REVISED ADDENDUM RESPONSE TO SUBMISSIONS AND UPDATED AMENDED PROJECT REPORT

**QANTAS FLIGHT
TRAINING CENTRE
SSD_10154**

20180199: LANDSCAPE ARCHITECTURAL DRAWING LIST

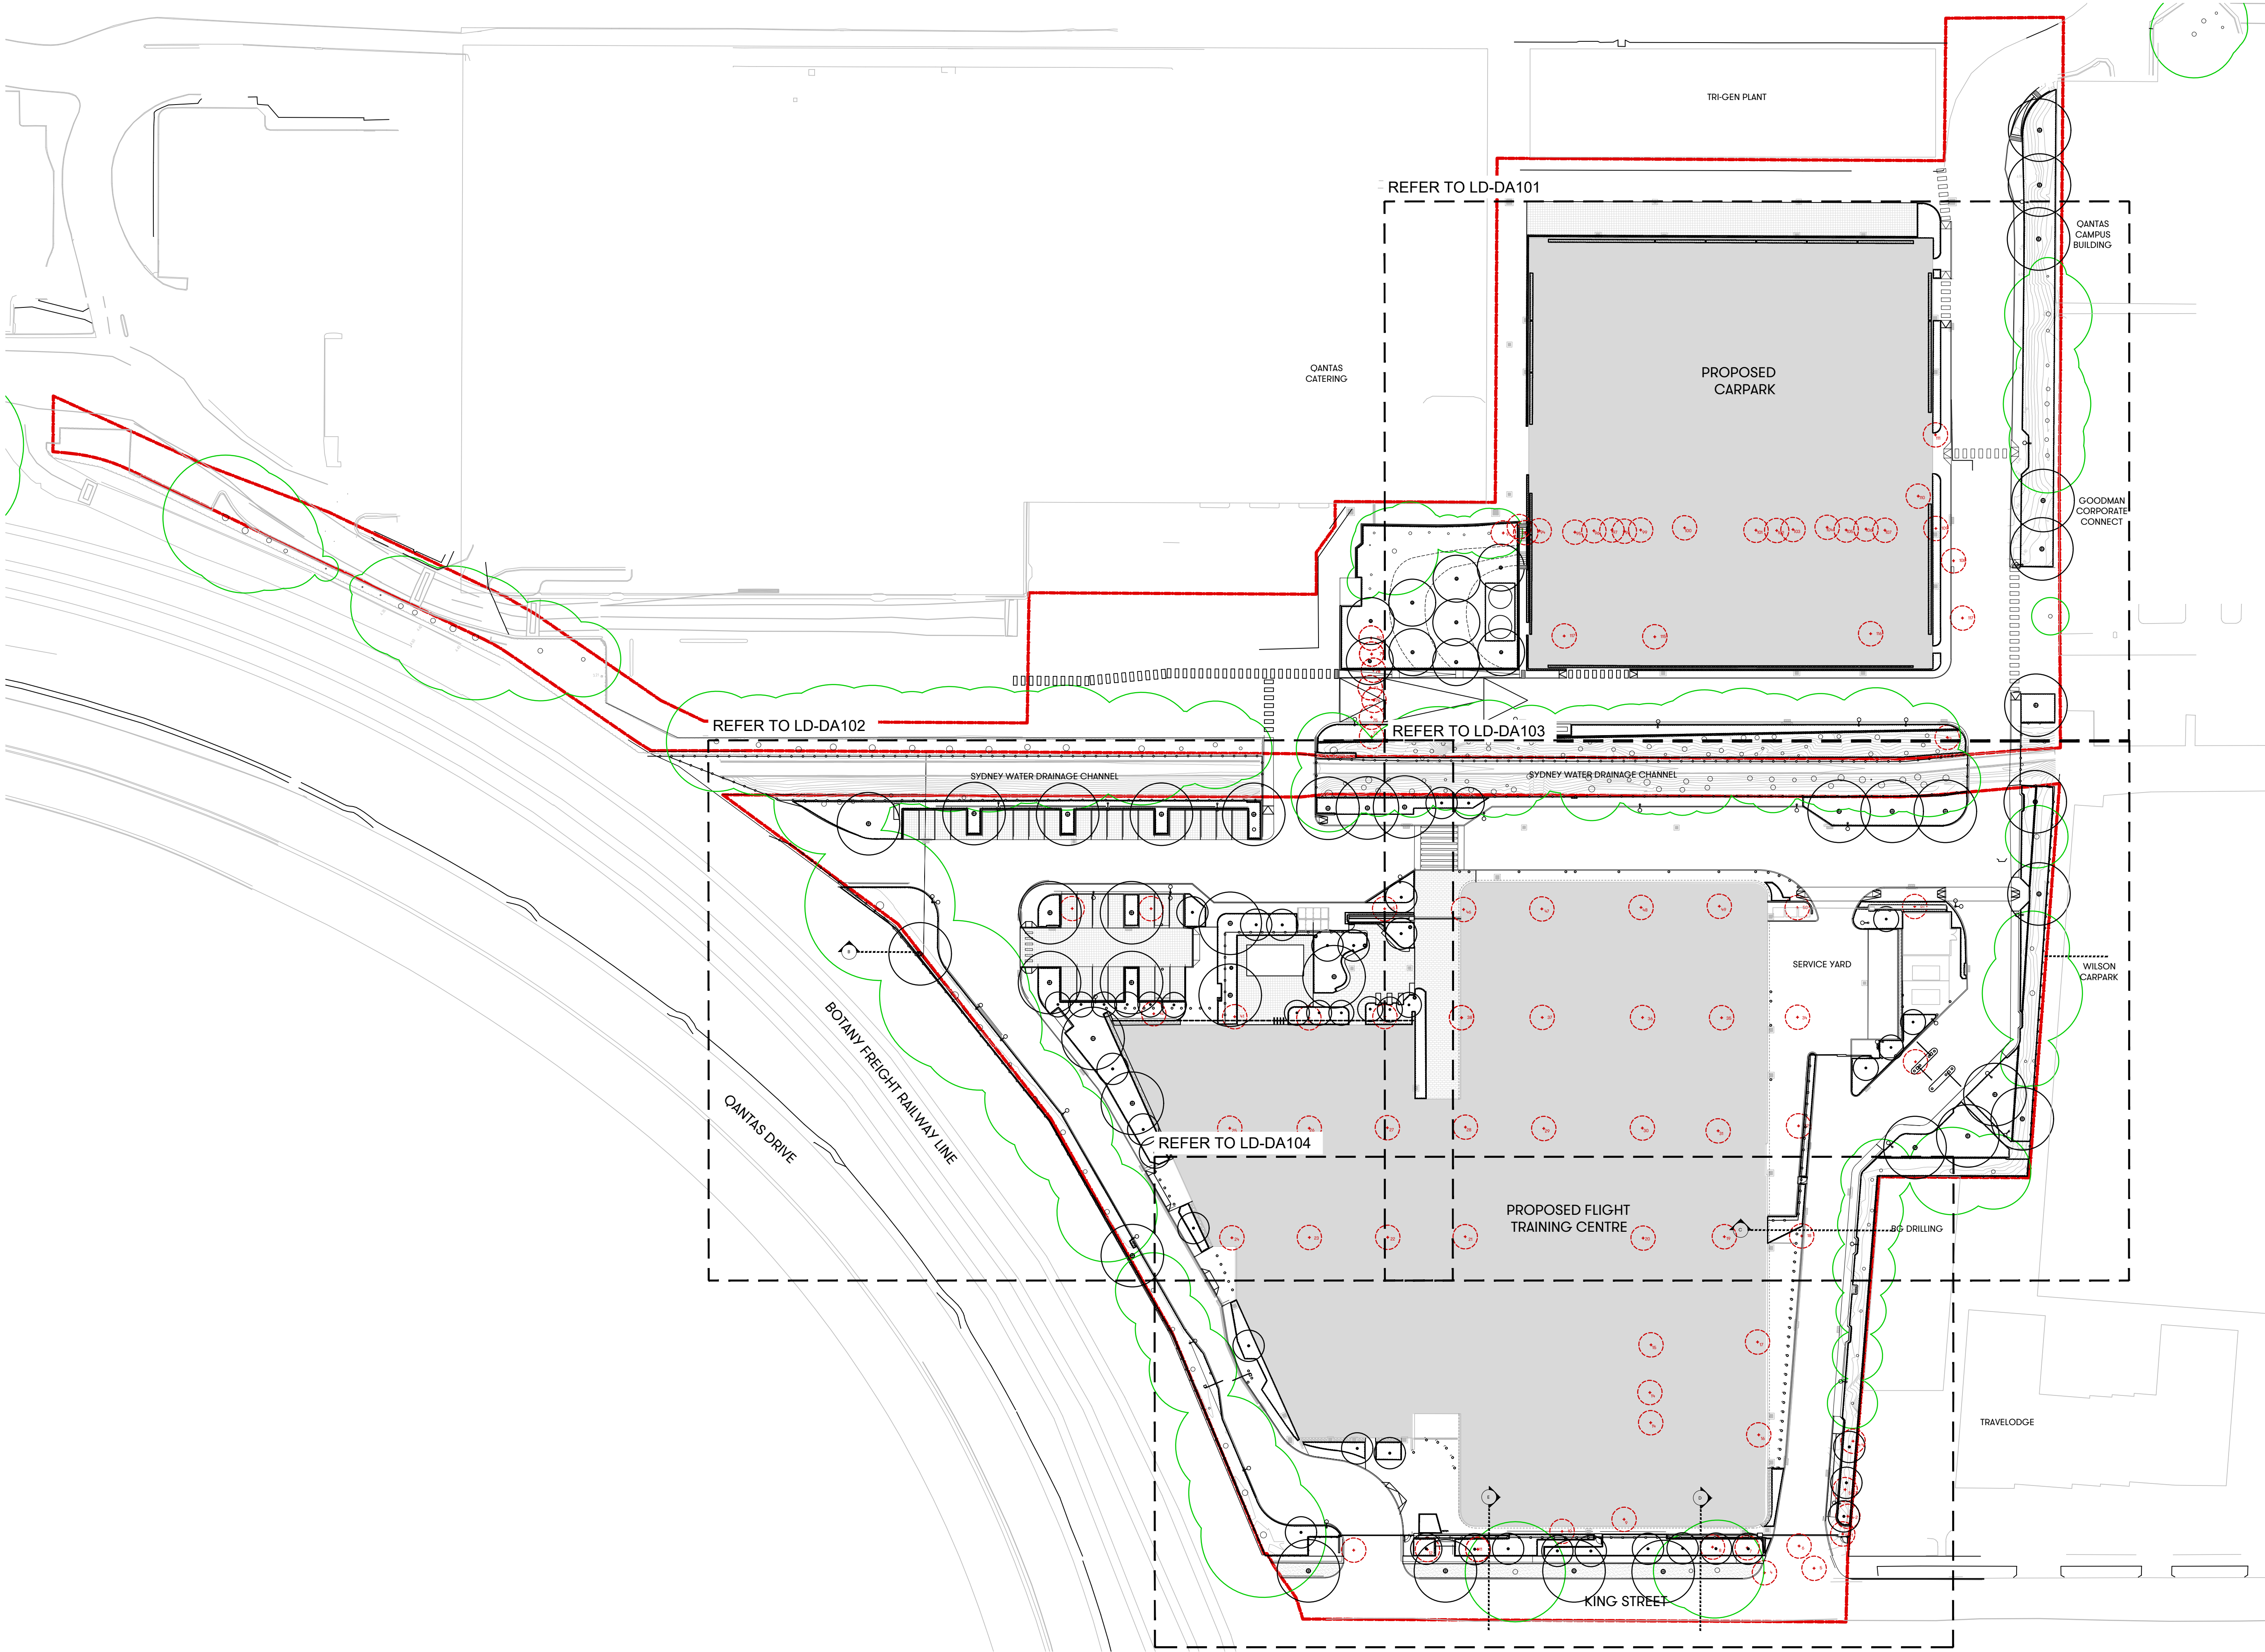
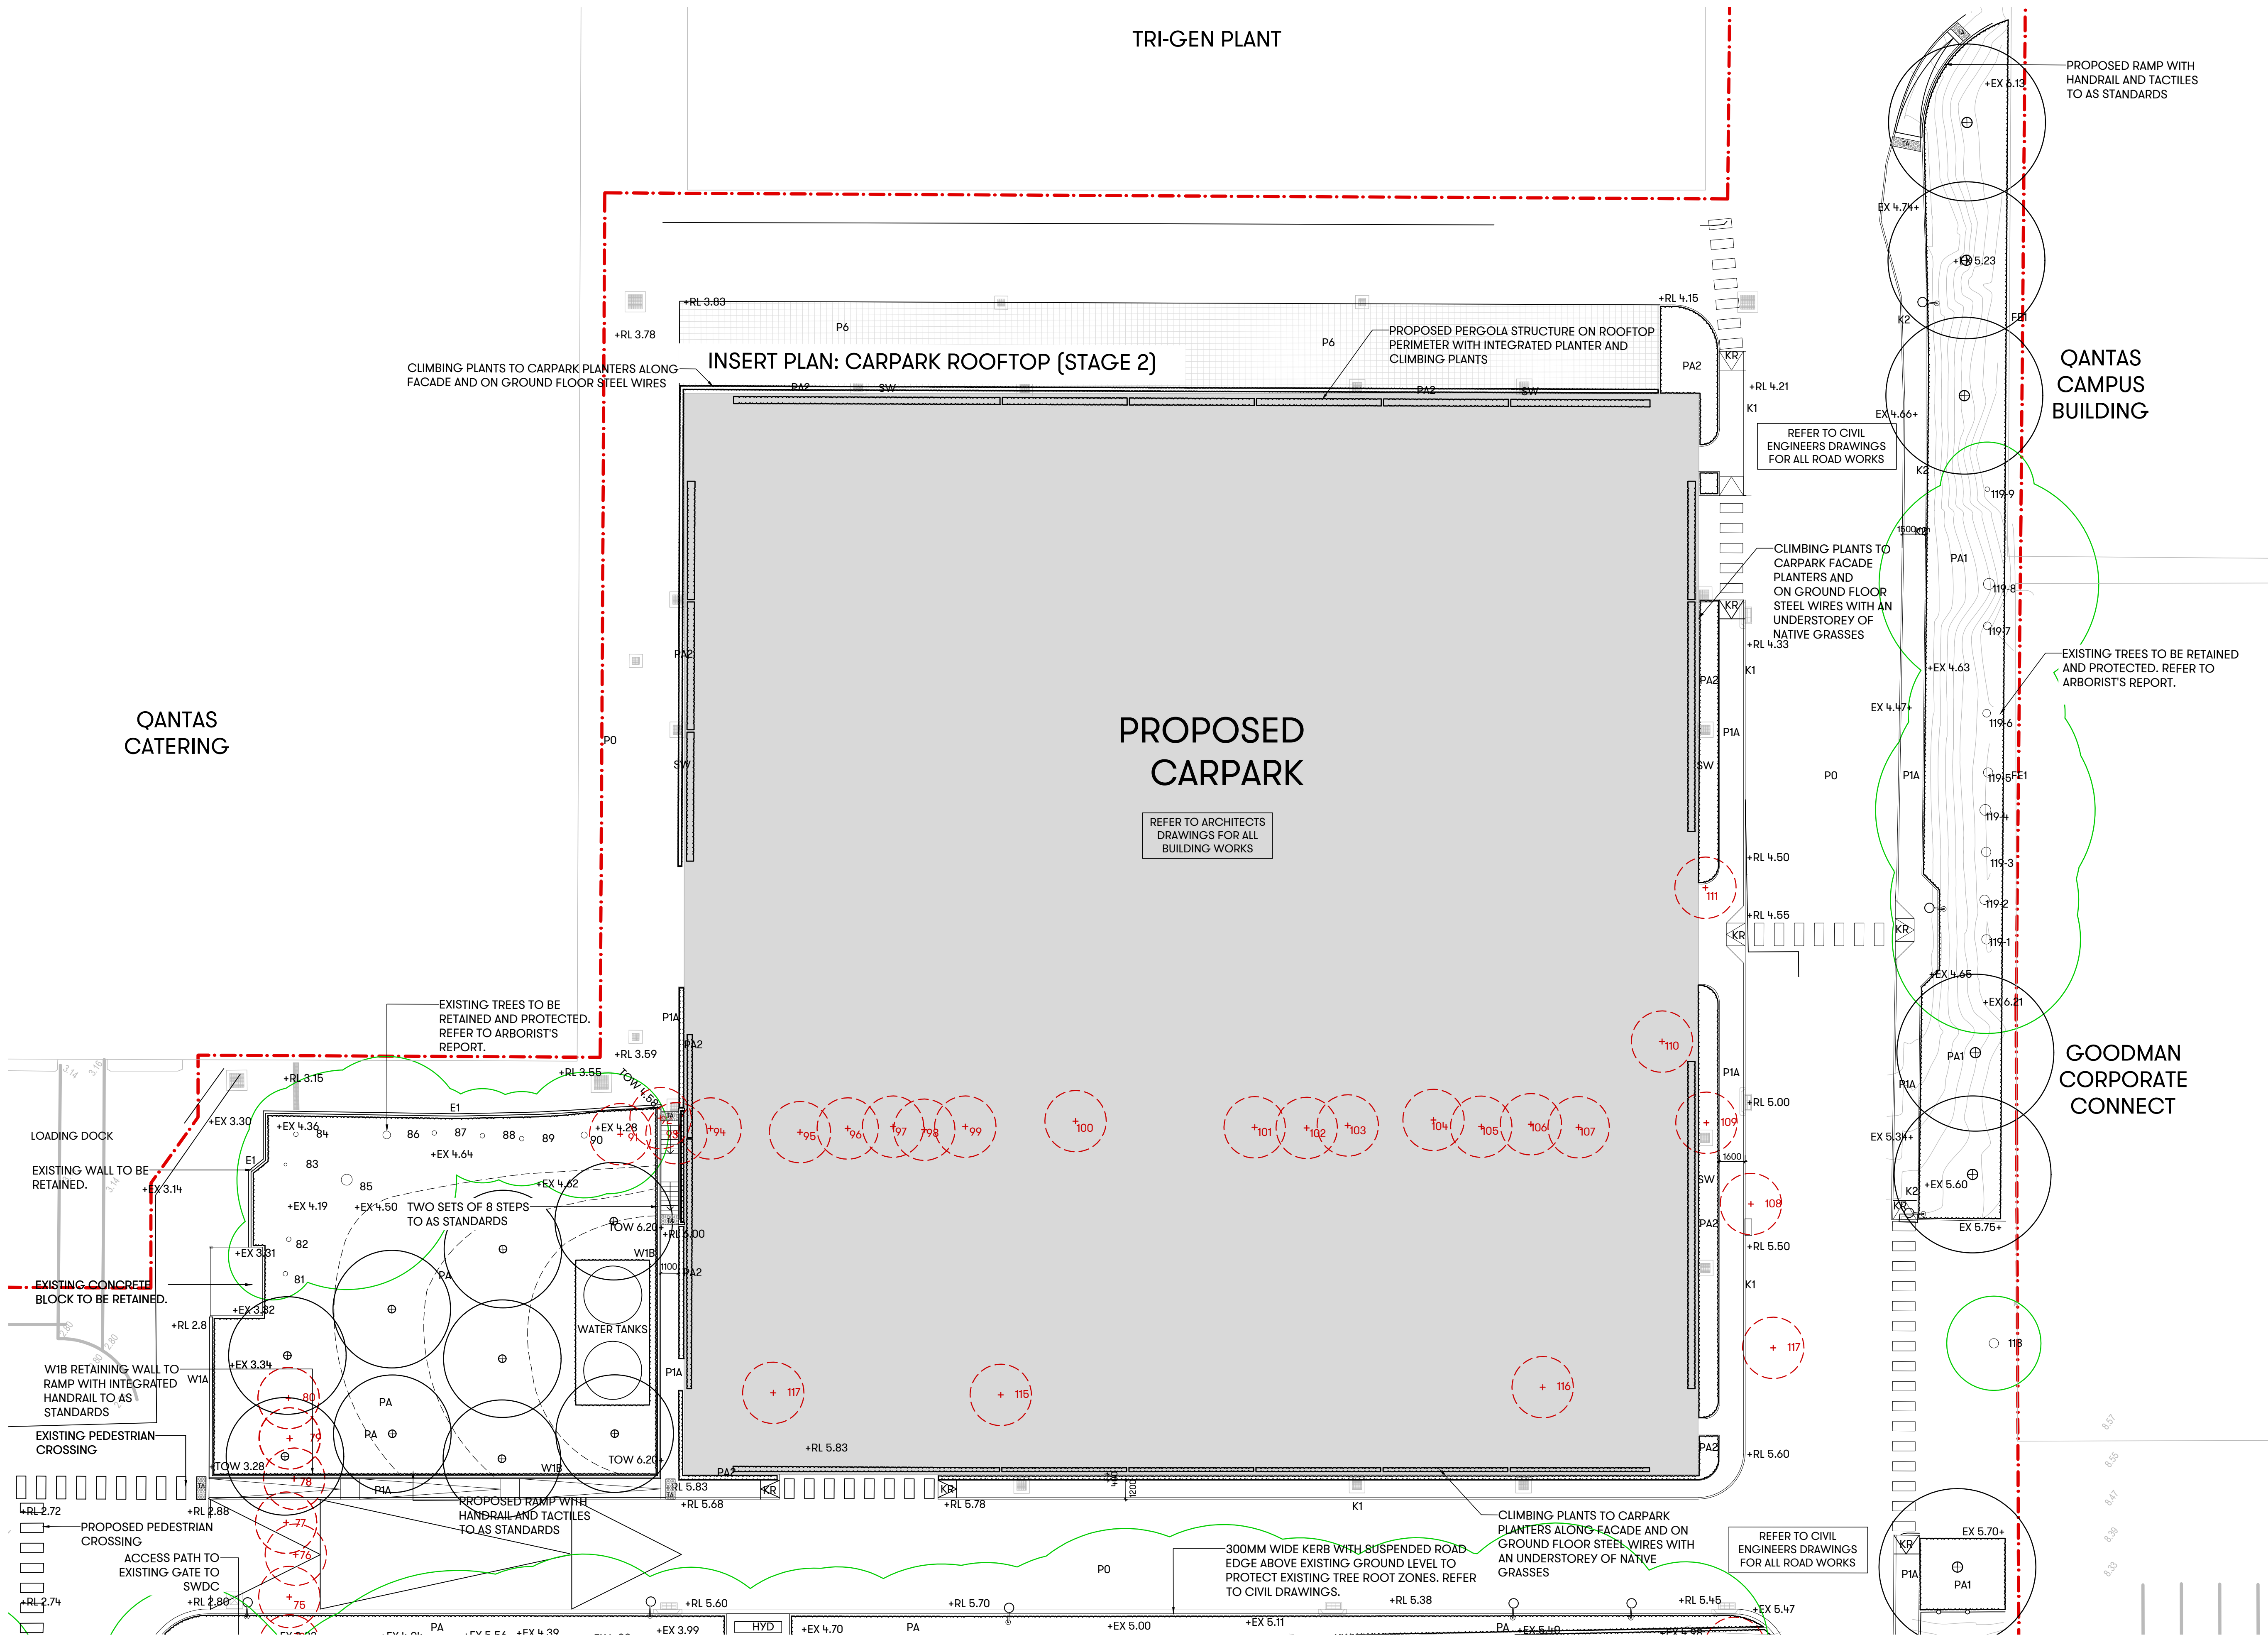
Landscape Architecture	<p>The amendments made to the proposal are supported subject to the inclusion of various conditions being included in the determination:</p> <p>1) The Final Landscape Plan shall be generally in accordance with the Landscape Plan prepared by Scott Carver, revision 2, dated 31st July 2019 and comprise detailed landscape construction documentation (plans and specifications) to be submitted to, and approved by Bayside Council's Landscape Architect the Principal Certifying Authority prior to the issue of the</p>	<p>The proposal for planters across the carpark facade currently are not intended to support trees. The proposal shows planters suitable for a mix of shrubs, groundcovers & climbing plants.</p> <p>The proposal includes irrigation connected to the rainwater tank to all proposed soft landscape in the King Street North but the carpark soft landscaping will be irrigated from potable water.</p>

<p>Construction Certificate. The landscape documentation shall include, but not be limited to:</p> <p>a) Planting plan at 1:100 showing all plant locations/ groupings and plant centres/ species. There is to be a dense layered planting scheme consisting of trees, shrubs and groundcovers in all of these areas.</p> <p>b) Construction Details of the proposed 21 façade planters that work as green walls and the bus shelter green roof, including details of planting; and a 12 months maintenance schedule of these elements.</p> <p>c) Elevated planter box sectional details and drainage details. All planter box depths and dimensions shall be in accordance with Council's DCP and capable of supporting medium and large trees a mix of shrubs, groundcovers & climbing plants.</p> <p>d) Specifications detailing soil and mulch finishes, root barriers, irrigation, edging and other landscape works such as retaining walls, steps, planter walls, feature walls, skateboard restrictions, tree pits, tree grates, tree guards, tree pit treatments.</p> <p>e) Construction/ section details for areas of paving, edge treatments, and tactile areas including a schedule of materials.</p> <p>f) Details of all fencing, privacy screening, arbors and the like, including elevations and materials visible to public domain areas.</p> <p>g) Details of all other hardscape landscape elements such as street furniture, pedestrian amenity lighting, bins, bollards, as required. Locations are to be clearly identified on plan. Sectional construction details and elevations to be provided.</p> <p>h) A Landscape Maintenance Schedule shall be submitted that covers a 12 month period to provide a guide to the landowner or occupier on how to best maintain the constructed landscaped areas; and is to include the following information:</p>	<p>Therefore, it is requested that the recommended condition is updated to reflect the above – amended condition in (red).</p>
